## **Colorado Springs, CO**

## **Final Report - Corrections Required** **Application No. LUPL-25-0008**

**Document Filename : 241010\_BLR Village C Land Use Plan.pdf**

# BANNING LEWIS RANCH - VILLAGE C

**PROJECT INFORMATION**

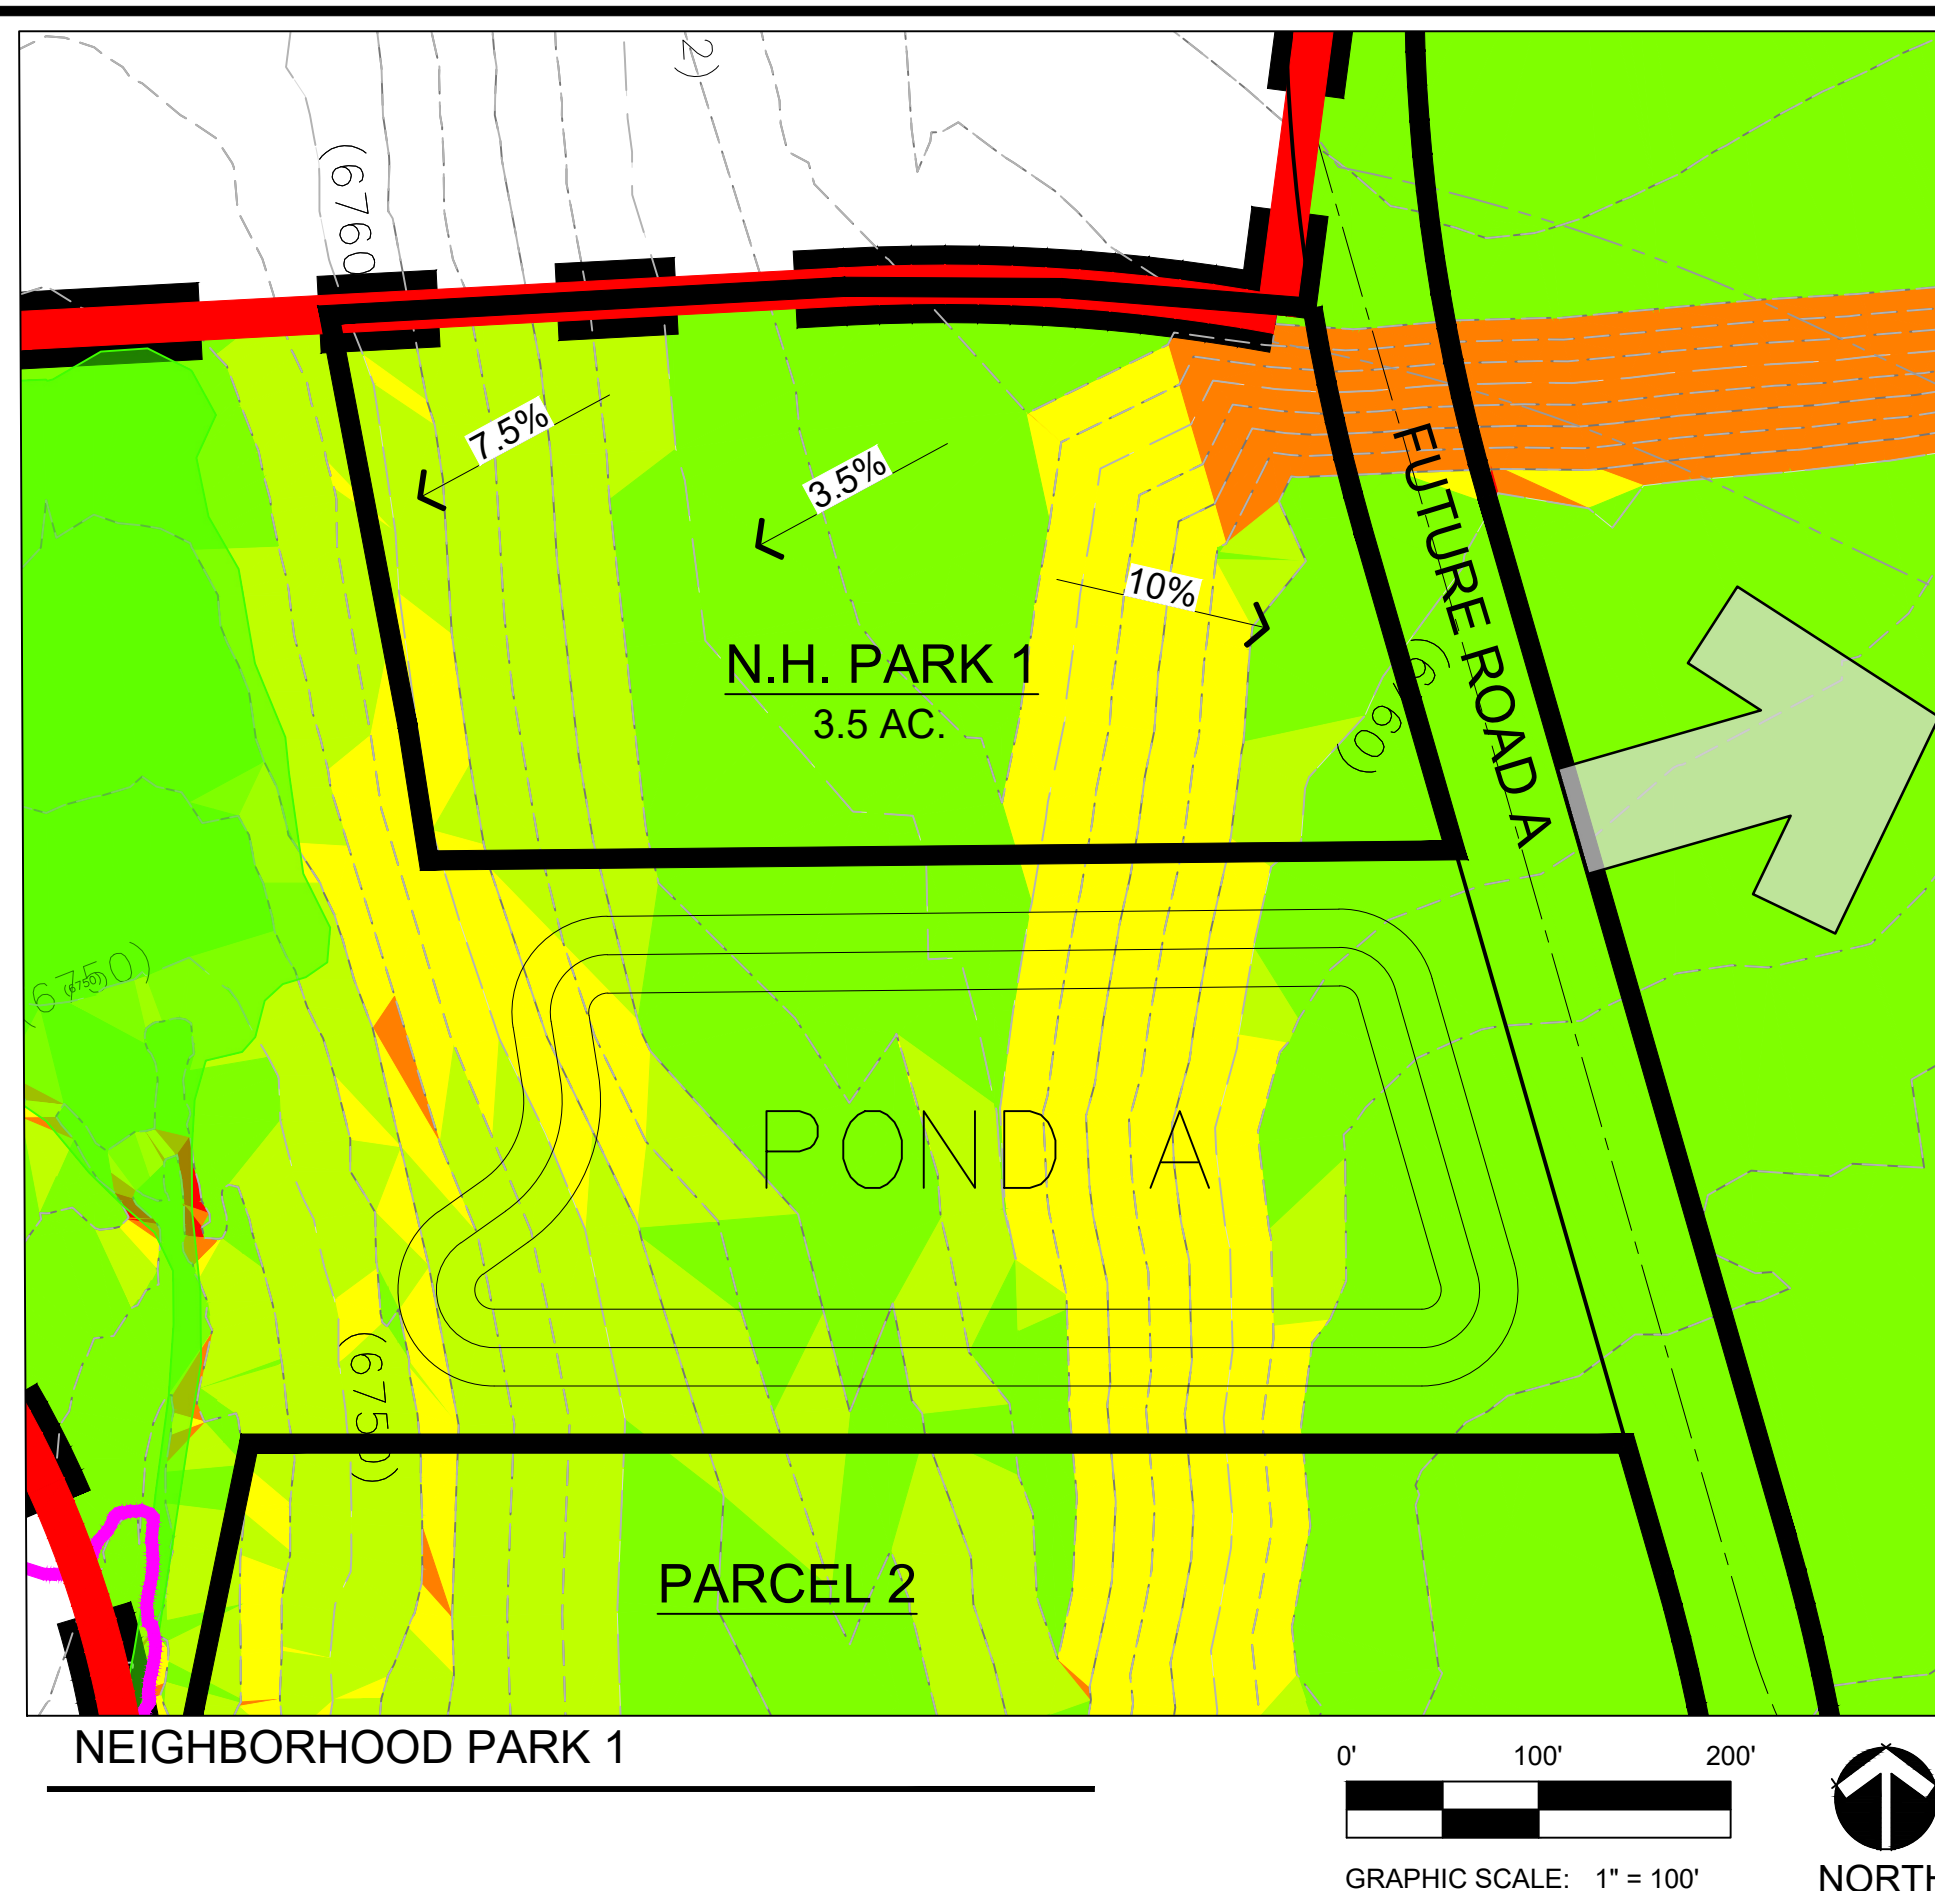
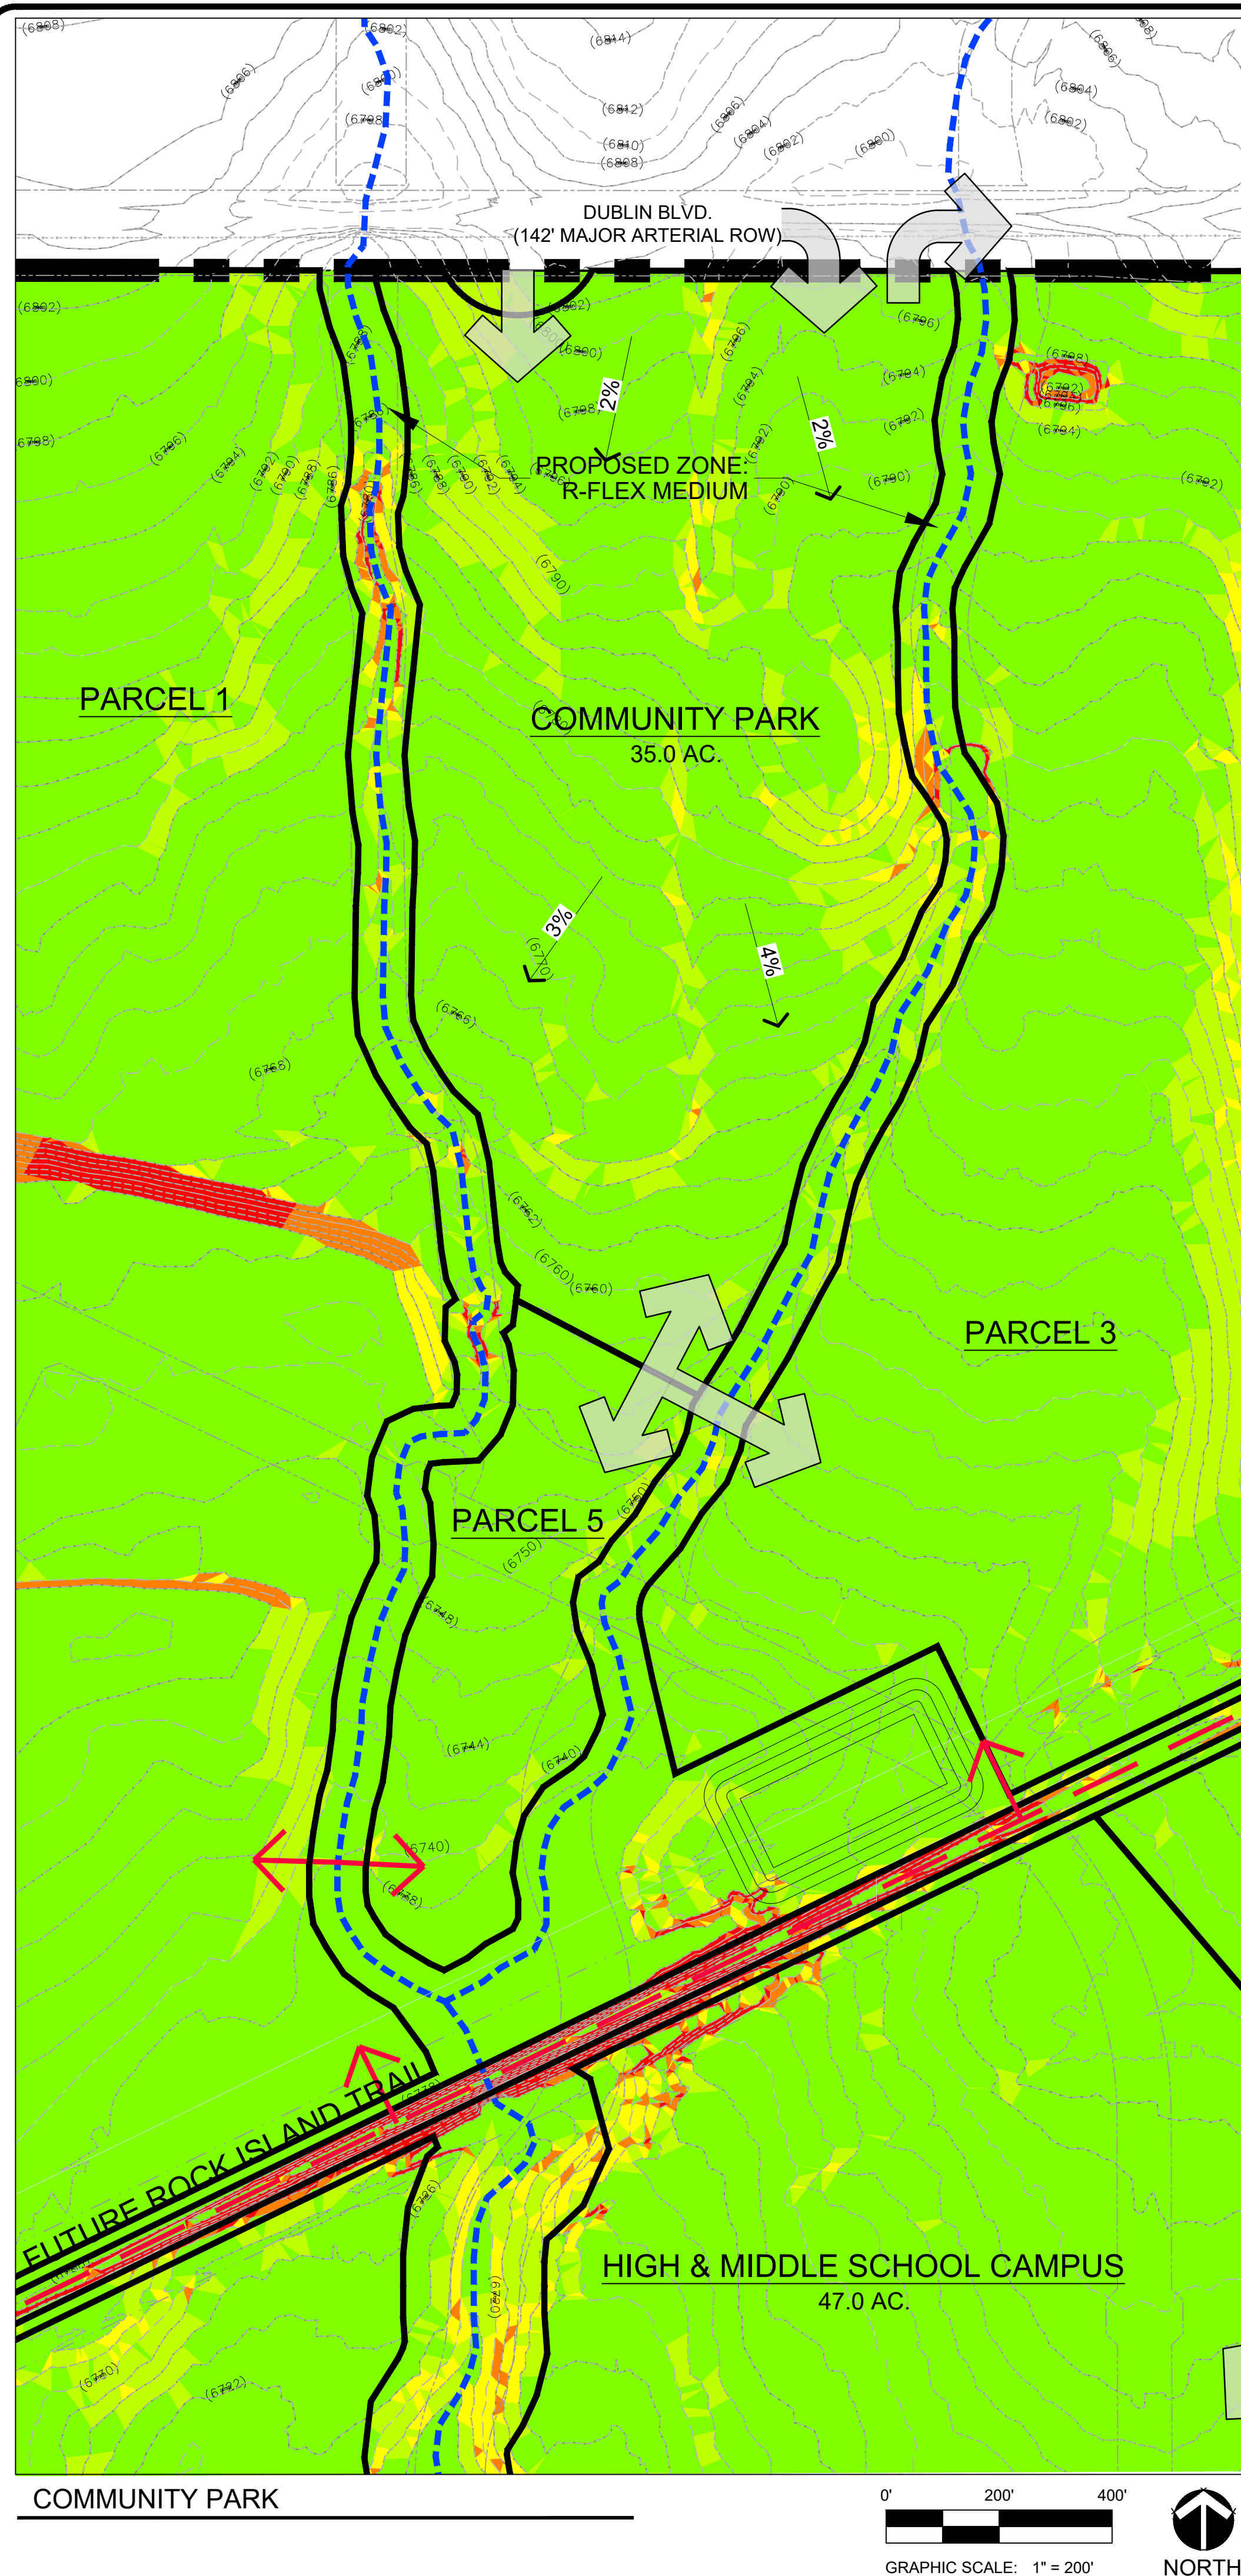
<b>Comment ID</b>	<b>Page Reference</b>	<b>Reviewer : Department</b>	<b>Review Comments</b>
2	2	Zaker Alazzeh : City Eng - Traffic Engineering	The developer shall dedicate the appropriate right-of-way along the northern property line of Parcel 6, located on Dublin Boulevard. This dedication must align with the western property line right-of-way existing roadway and meet the city's standards. Please coordinate with city traffic engineering on the ROW dedication.
1	1	Matthew Alcuran : Col Springs Utilities	**Springs Utilities comment to applicant: Springs Utilities comments will be provided at the time of the required Preliminary Utility and Public Facilities Plan submittal associated with the development plan entitlement.
